Phone: 0300 123 6780
Email: developeras@lancashire.gov.uk
Your ref: 3/2026/0351
Our ref: 3/2026/0351/HDC/KW
Date: 01 July 2026

Location: Land adjacent to Hothersall Lane Hothersall PR3 2XB
Proposal: Change of use of agricultural building to commercial livery stables and formation of sand paddock, parking, turning area and drainage attenuation pond.
Grid Ref: 361950 436723

Lancashire County Council acting as the Local Highway Authority does not consider that the application as submitted fully assesses the highway impact of the proposed development and further information is required as set out in this response. Without this information the Local Highway Authority is unable to provide final highway advice on this application.

PROPOSED SITE PLAN

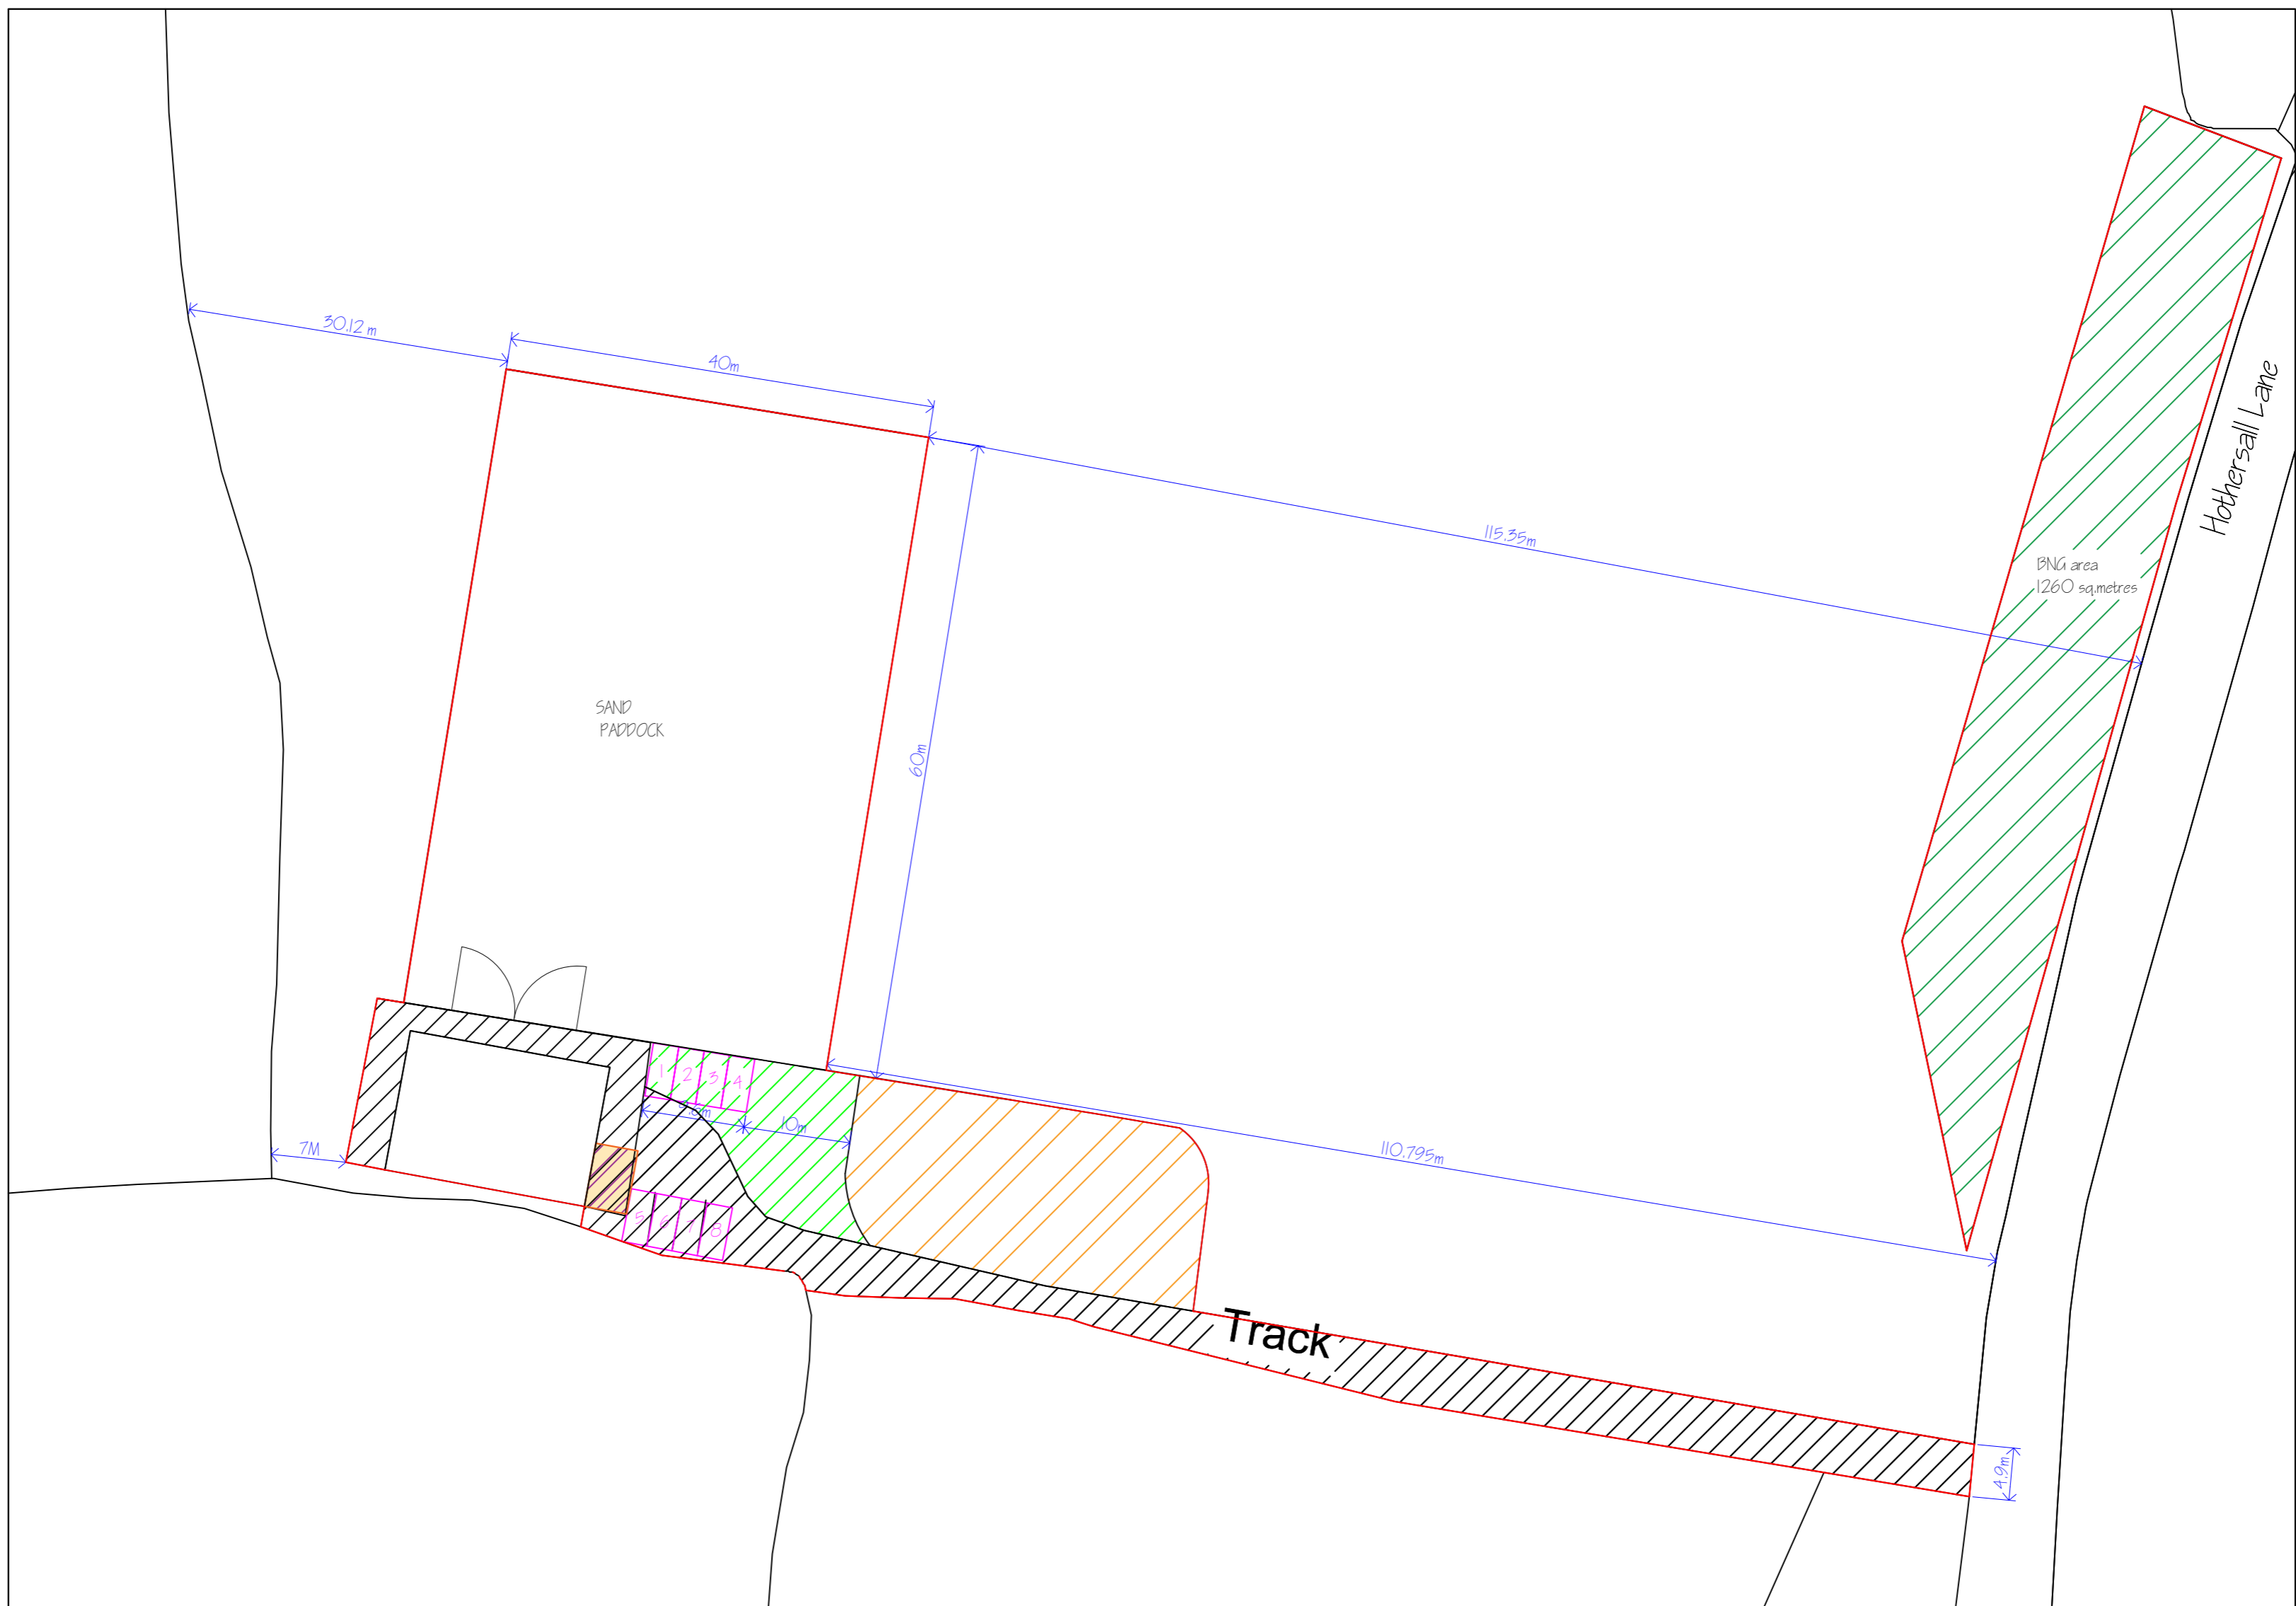
The site currently has an existing field gate access which measures approximately 4.9m wide onto Hothersall Lane, which is an unclassified road, subject to a national speed limit. Following the intensification of use, the site access will need to be upgraded to support two-way movement and vehicle turning into and out of the access with a vehicle and horse box trailer.

Agricultural access should be an appropriate width for the largest vehicle expected to access the site. The LHA therefore requests that a swept path analysis be provided showing the largest vehicle which will be accessing the site following the development. The LHA would also request that the access support ingress and egress for two vehicles

to pass each other to prevent any waiting within the highways or overrunning of the verges.

Furthermore, the LHA will require a swept path drawing of the largest vehicle turning within the site. This is to ensure that the area is suitable and that an adequate turning area is provided to enable the vehicle to exit in a forward gear.

A detailed site access drawing will be required in which the LHA would require the access to be hard paved for at least 10m into the site to prevent. Whilst the current access is gated, the LHA would look for any retained gates to be set back enough to allow a horsebox or a car and trailer to enter the site before operating the gates as such the gates should be set back at least 10m from the carriageway edge.

The site access road leading to the parking area is approximately 5m wide for 70m into the site, where it narrows to single width for 30m adjacent to the attenuation pond before entering the car parking area.

The proposal provides parking for up to 8 vehicles and includes dedicated turning space. However, a swept path analysis drawing showing turning for the largest vehicle accessing the site within the car parking area is required to determine that the site has adequate parking and will not conflict with manoeuvring.

- Safe ingress and egress of the largest anticipated vehicle at the site access.
- The ability for vehicles to pass at the access arrangement without impacting the public highway or highway verge.
- Adequate on-site turning facilities enabling the largest vehicle to enter, manoeuvre and leave the site in a forward gear.

In addition, a detailed access drawing should be submitted showing the proposed access improvements, including surfacing details and gate positioning. Any proposed gates should be set back sufficiently to allow vehicles and horsebox/trailer combinations to clear the carriageway before opening.
